**APPLICATION BY MORGAN OFFSHORE WIND LIMITED AND  
MORECAMBE OFFSHORE WINDFARM LIMITED FOR A  
DEVELOPMENT CONSENT ORDER FOR THE MORGAN AND  
MORECAMBE OFFSHORE WIND FARMS TRANSMISSION ASSETS**

**DEADLINE 7 SUBMISSION – CLOSING STATEMENT**

**BY LANCASHIRE COUNTY COUNCIL**

**29<sup>th</sup> OCTOBER 2025**

Figure 1.4: Indicative areas of habitat creation and enhancement at the Morgan onshore substation

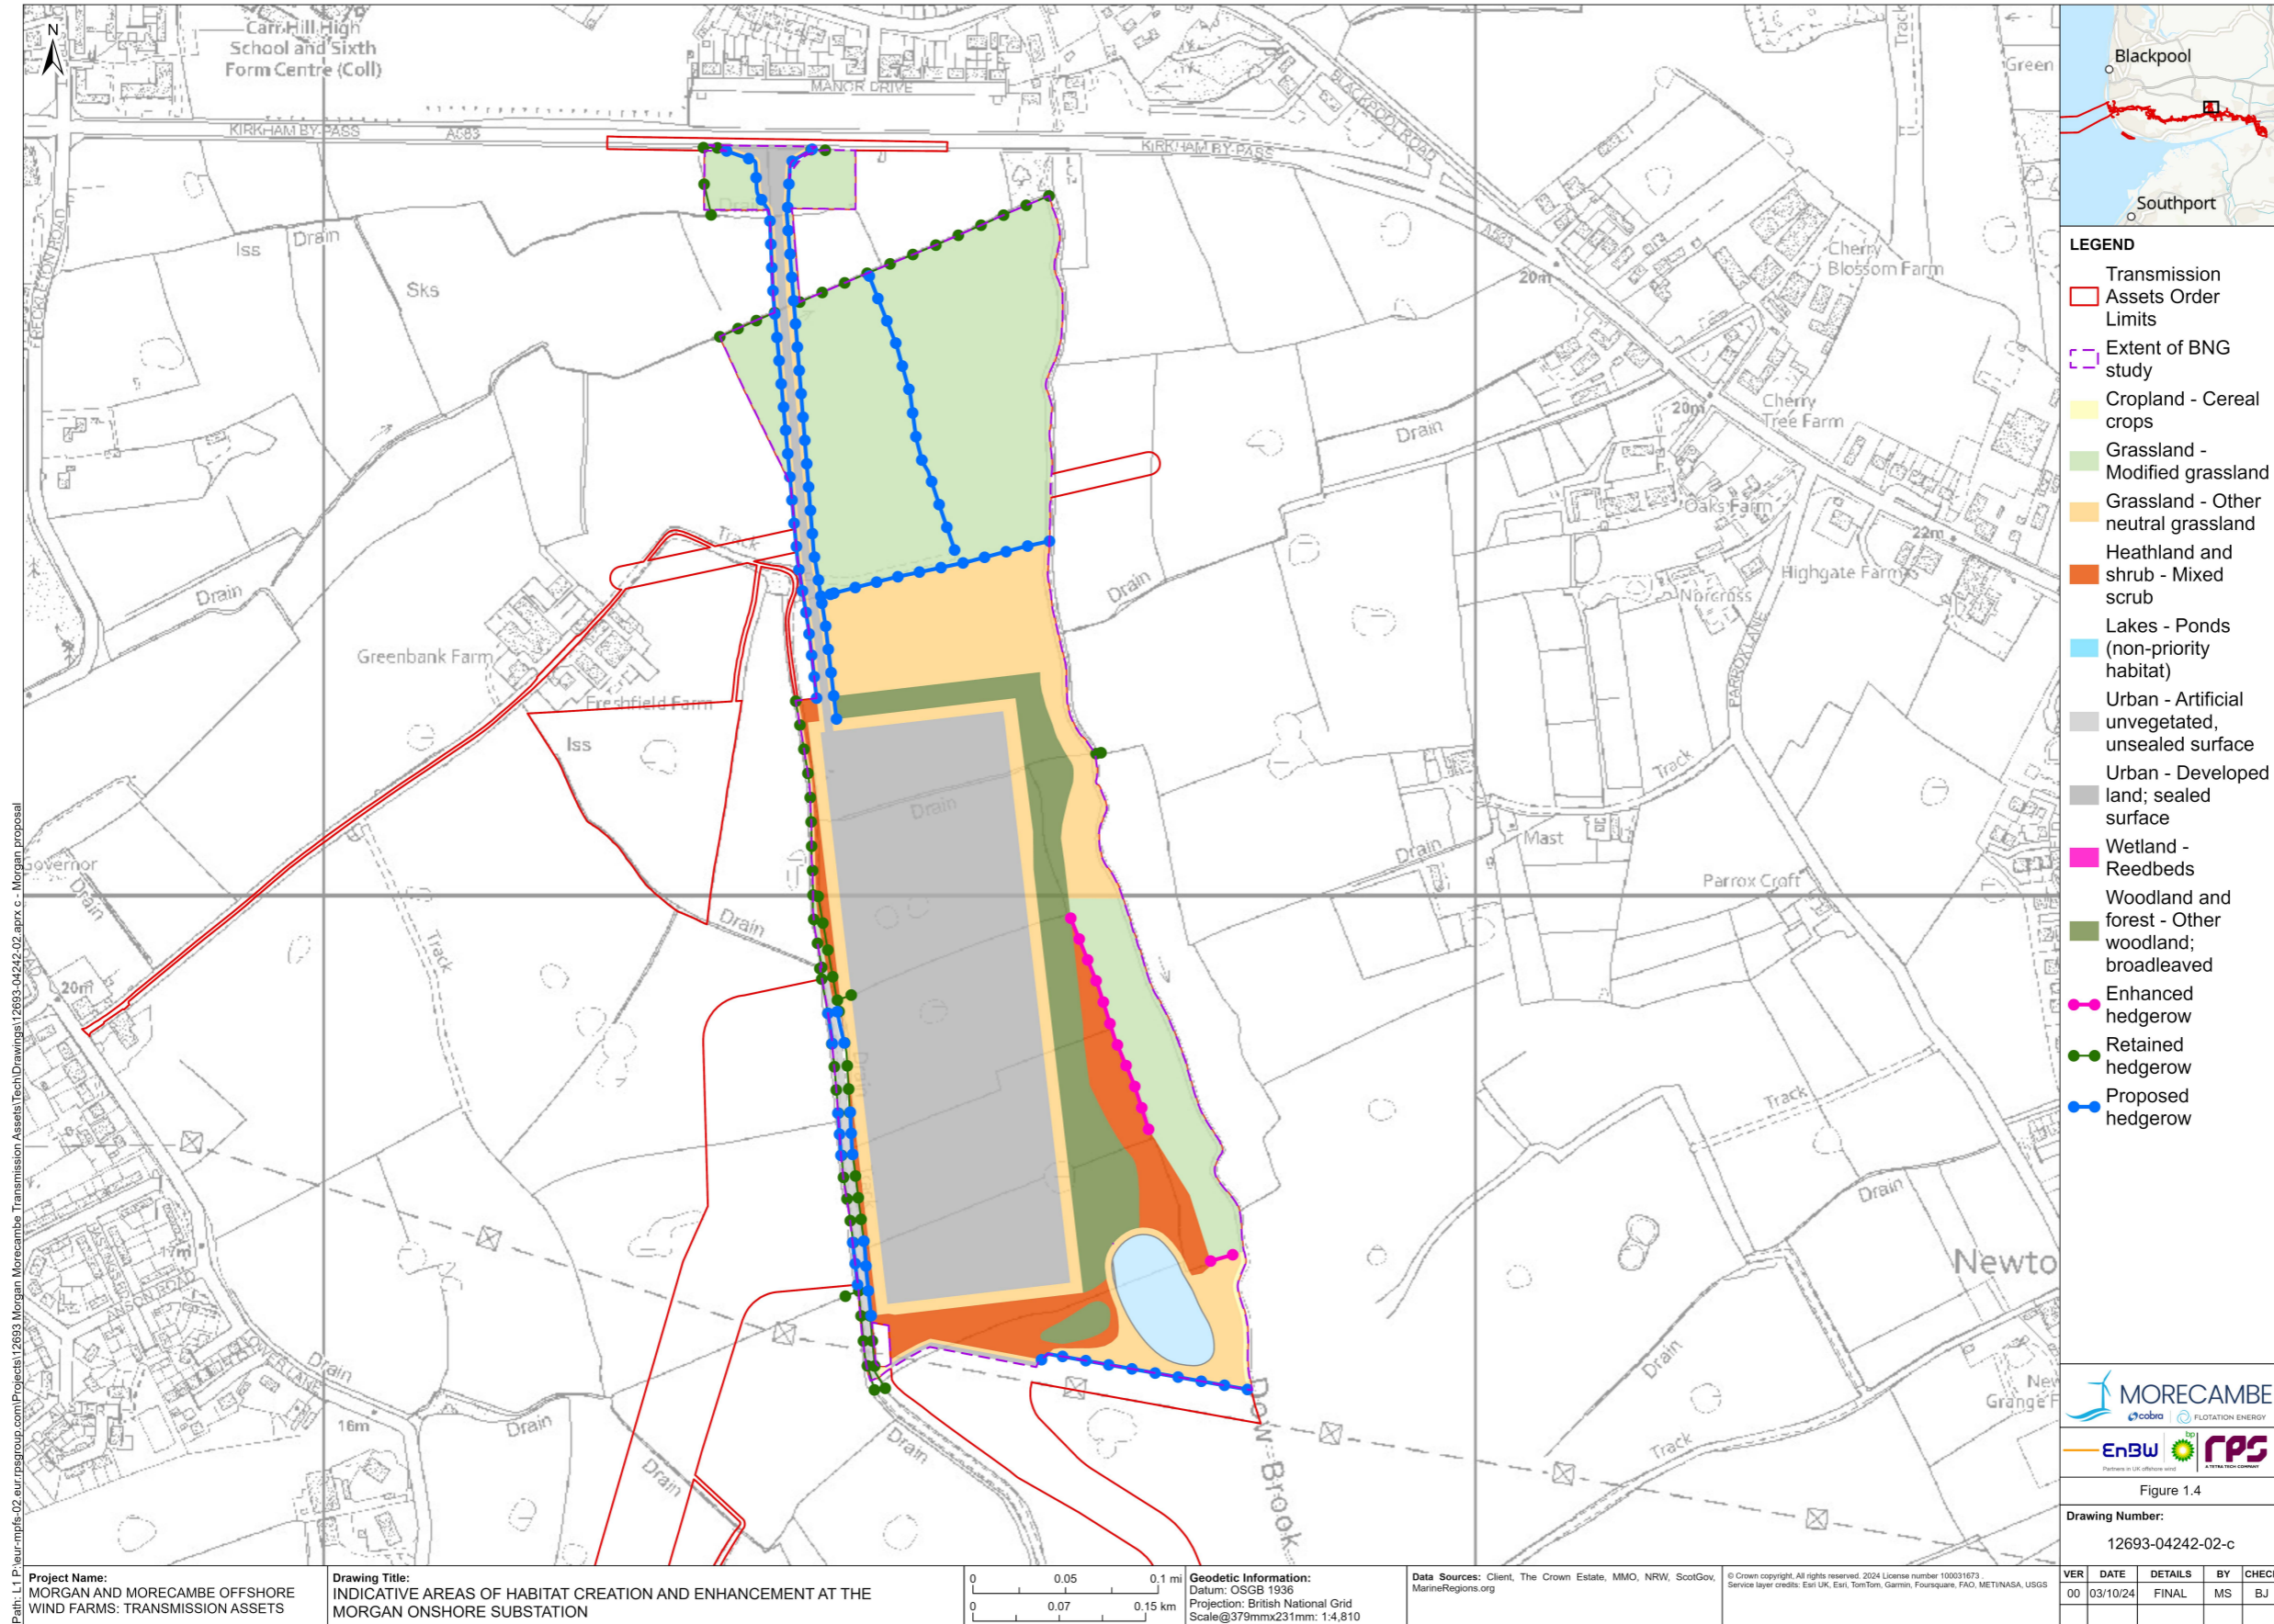
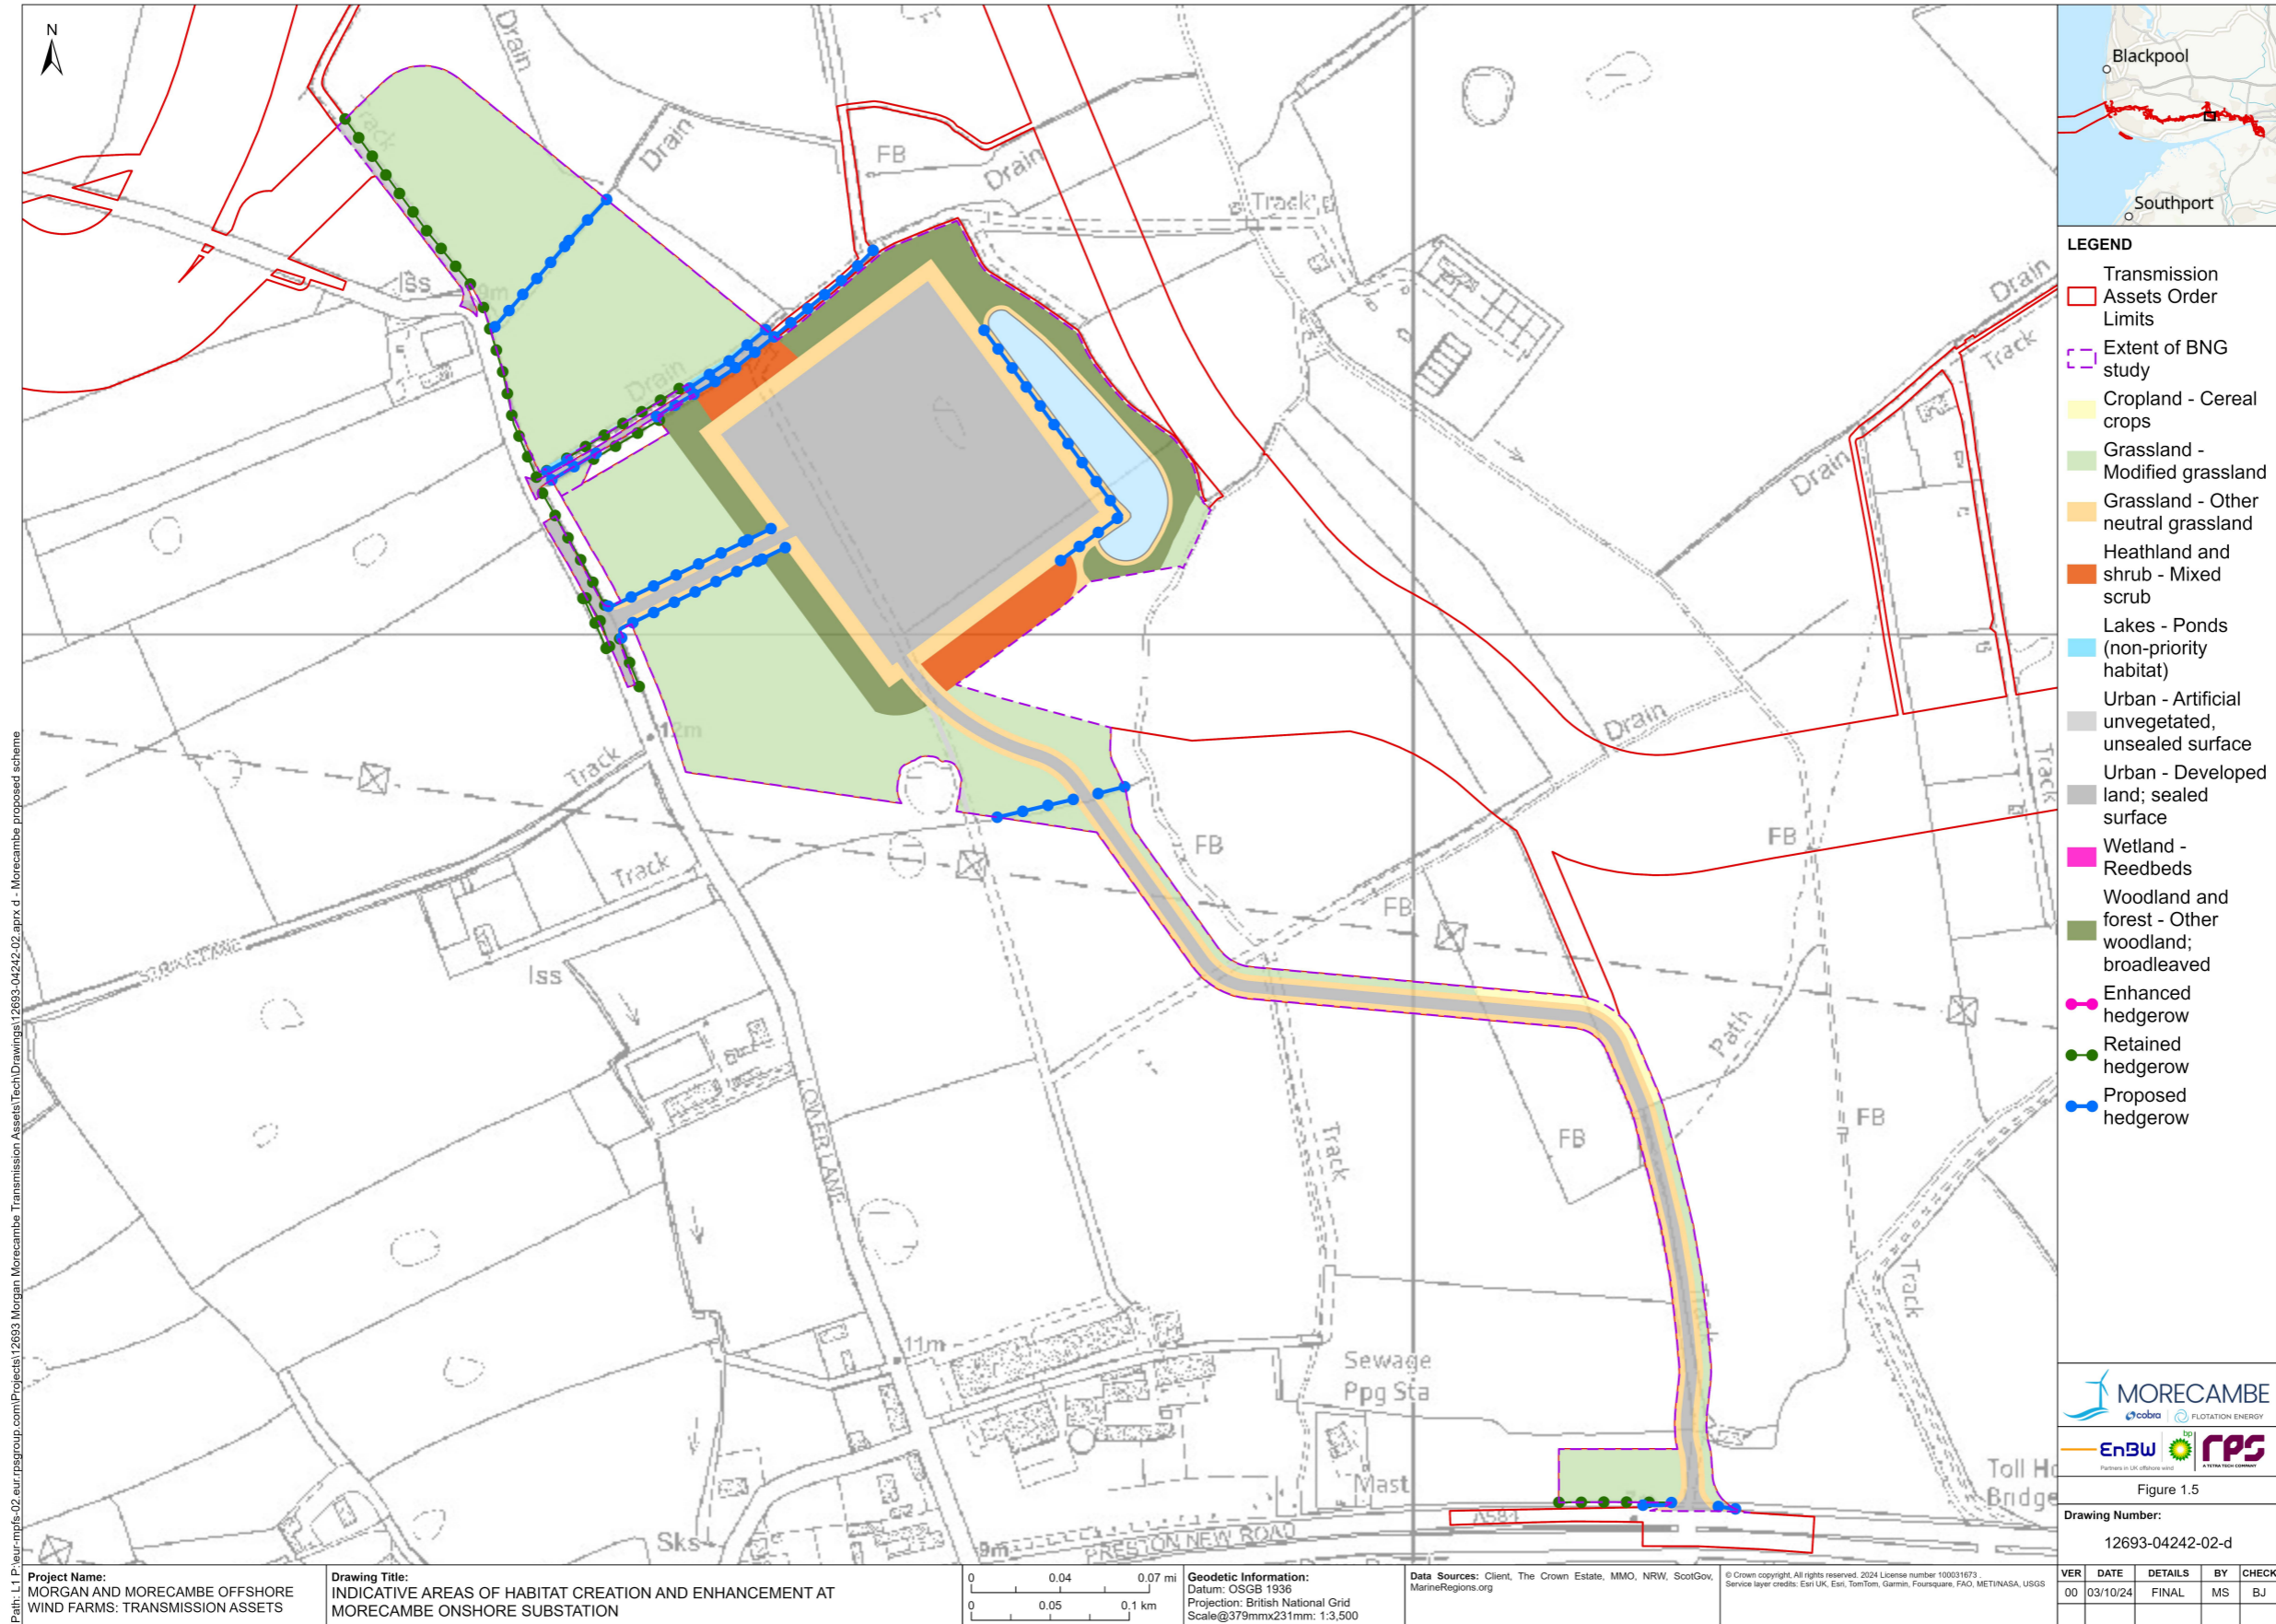
- 4.5 The primary area of concern is the landscape and visual impacts of the two substation sites. Again mitigation should aim to replicate and strengthen existing landscape patterns. This entails not a random assortment of ponds in one tiny area, but scattered throughout the adjacent fields as is the existing pattern; woodland planting comprising irregular blocks, not a thin line which further emphasises the location and presence of the built form and development; strengthening of hedgerows, both existing and the re-establishment and replacement of post and wire fence boundaries, particularly where this is of benefit to reducing visual impacts from Public Rights of Way (PRoW) south of the Morecambe substation. Considered, strategic and relatively minimal off site planting, which helps to reduce visual impacts for those living closest to the site or relying on views for their business USP, or helps maximise levels, gradients and planting on site by positioning attenuation ponds off site. The NPS's suggest off site mitigation as a means of achieving better integration and mitigation yet this has not been proposed.
